Item No. **Report of the Head of Planning, Building Control, Sport & Green Spaces**

Address LAND FORMING PART OF 2 PEACH TREE AVENUE YIEWSLEY

Development: Two story, 1-bed, end of terrace dwelling with associated parking and amenity space involving installation of 2 crossovers to front

LBH Ref Nos: **70772/APP/2015/2912**

CLIENT	MR ALI LATEEF	SCALE	1:100
PROJECT	2 PEACH TREE AVENUE, UB78DH	DATE	FEB'2015
TITLE	SIDE EXTENSION AND NEW DWELLING PROPOSED FRONT AND REAR GARDEN	DRAWN	AR
		CHKD.	AR
DRG No.	UB78DH-DWG-109	REV.	06
		APPD.	AR

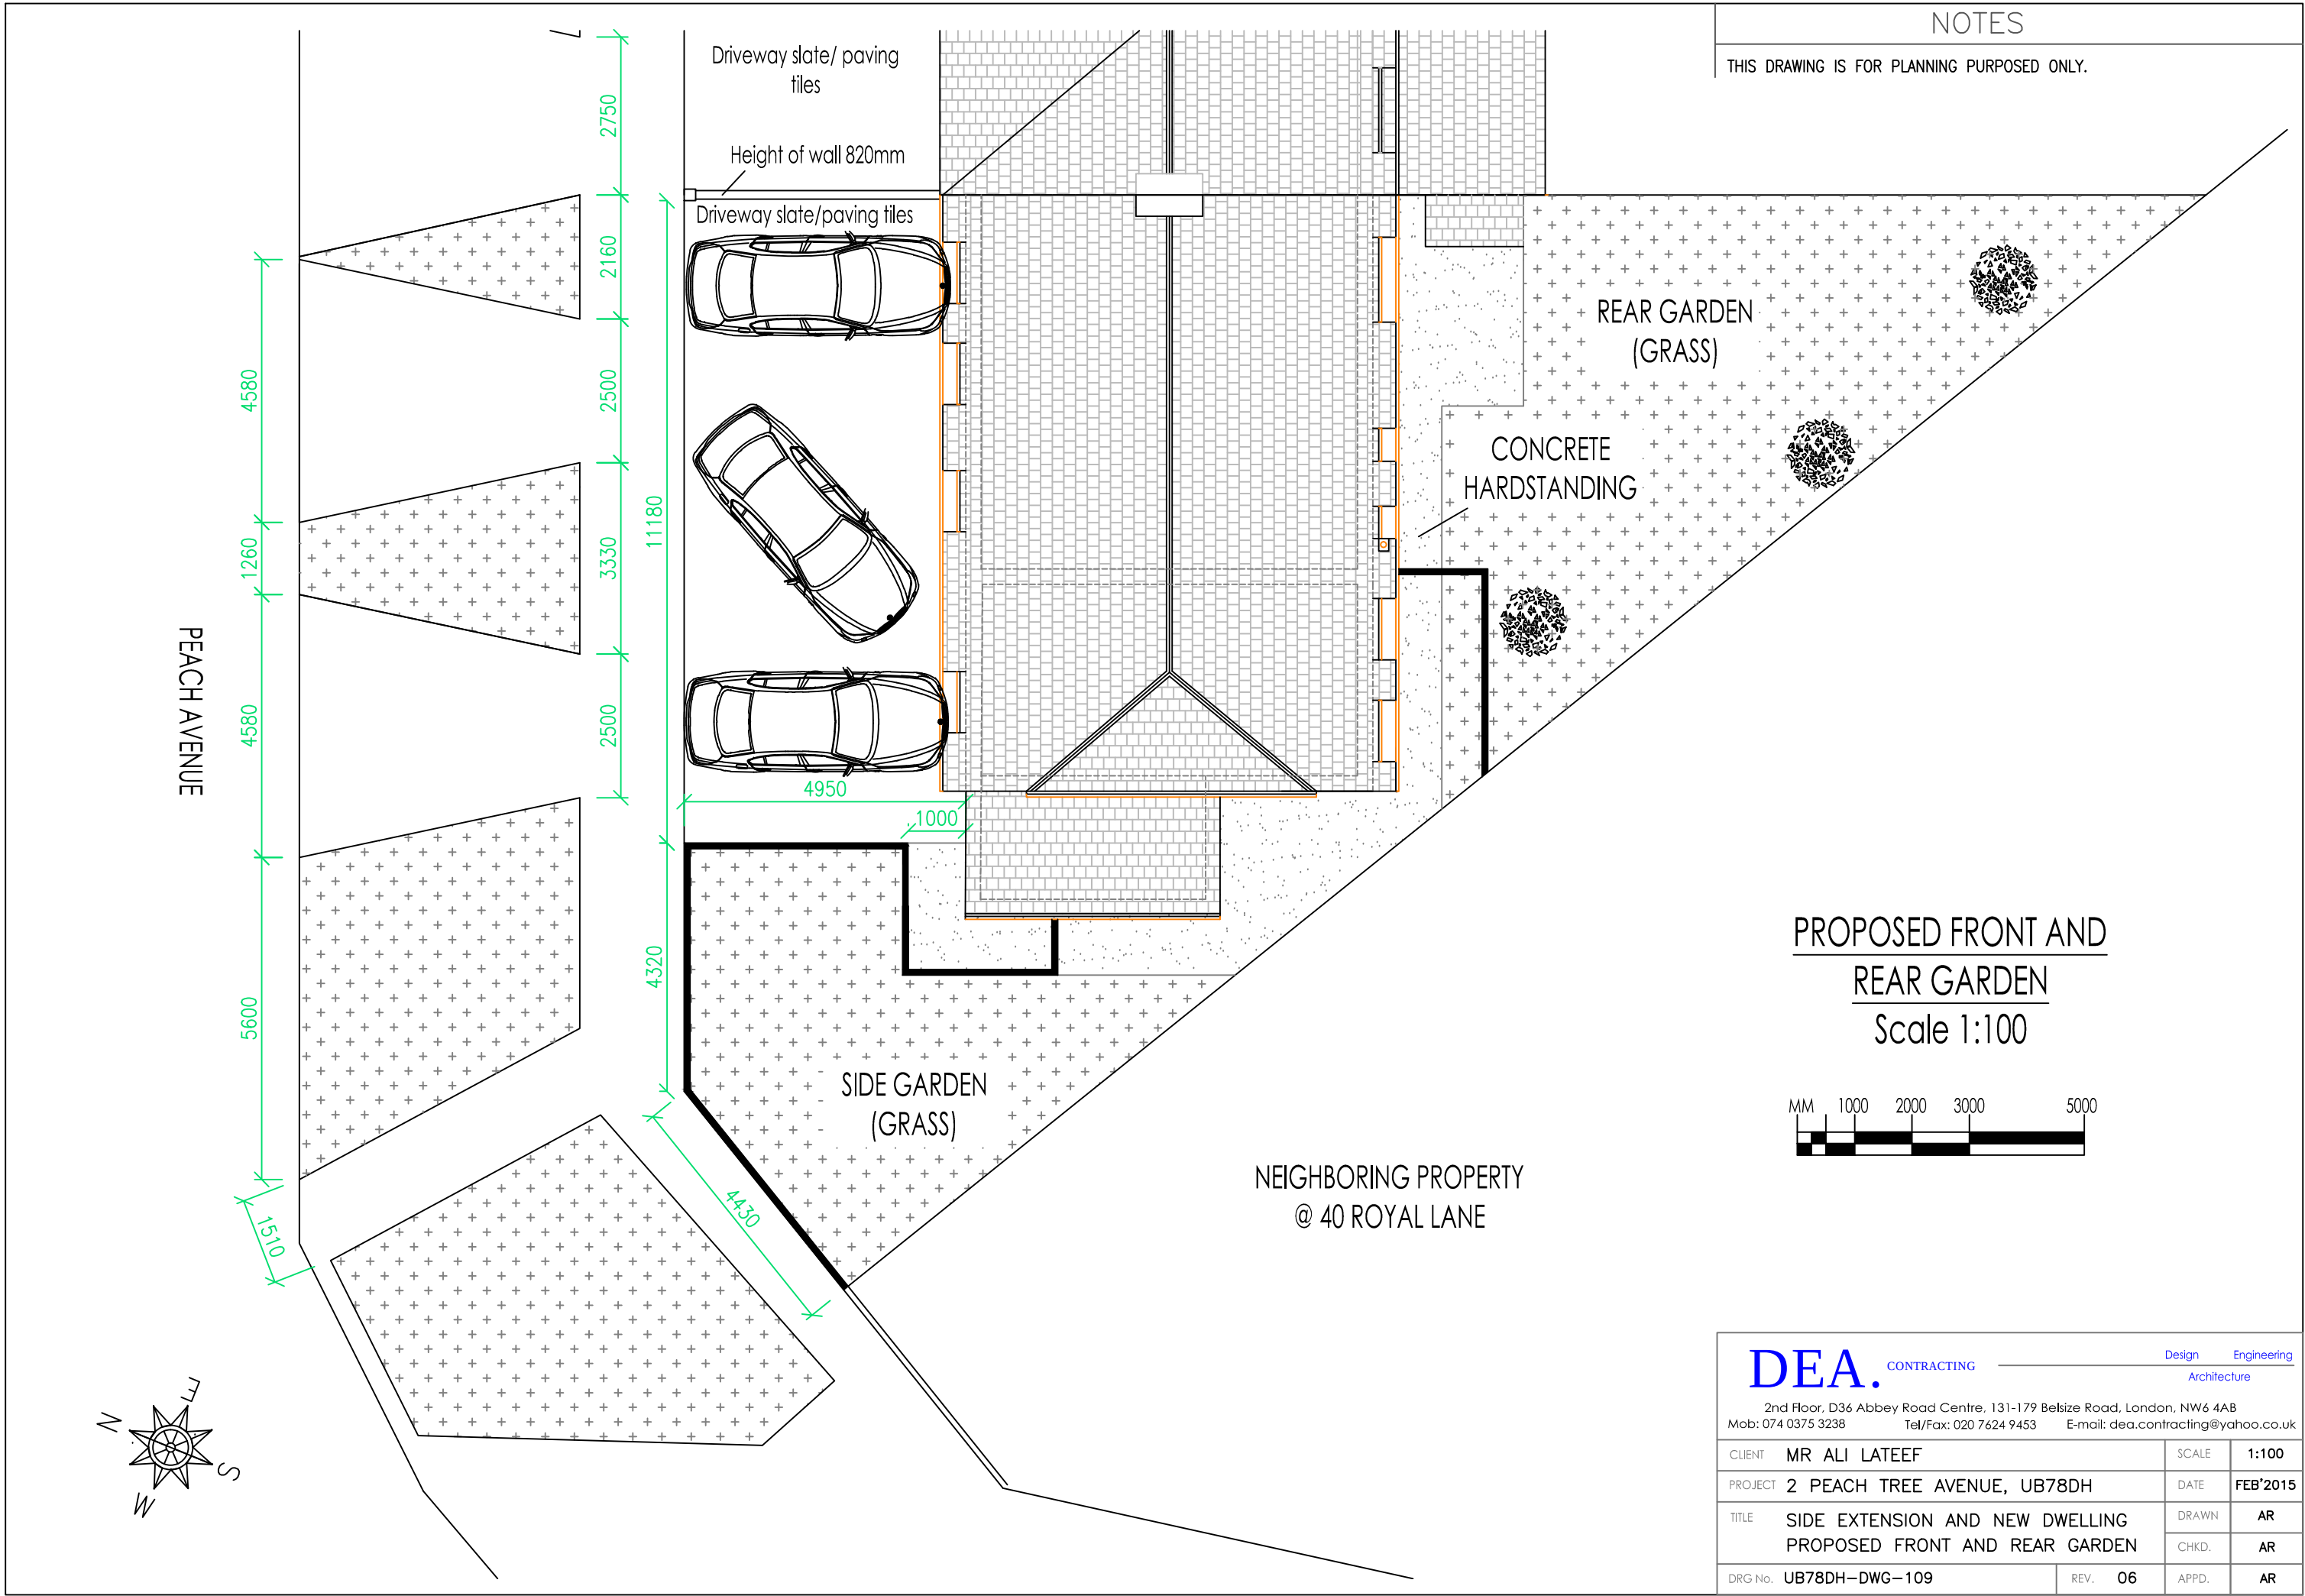
a. The revised layout is acceptable in principle - however the position/width of the crossover needs minor modifications to centralise/widen and ensure that shared use is practical for both dwelling. Please request for the crossover to be widened from 4.5 to 5m and for position to be centralised.

Subject to your confirming the dimension of the forecourt as discussed, there are no highway objections.

Officer Comment: Confirmation of depth of the frontage as measured on site on 7.10.15 is 4.98m
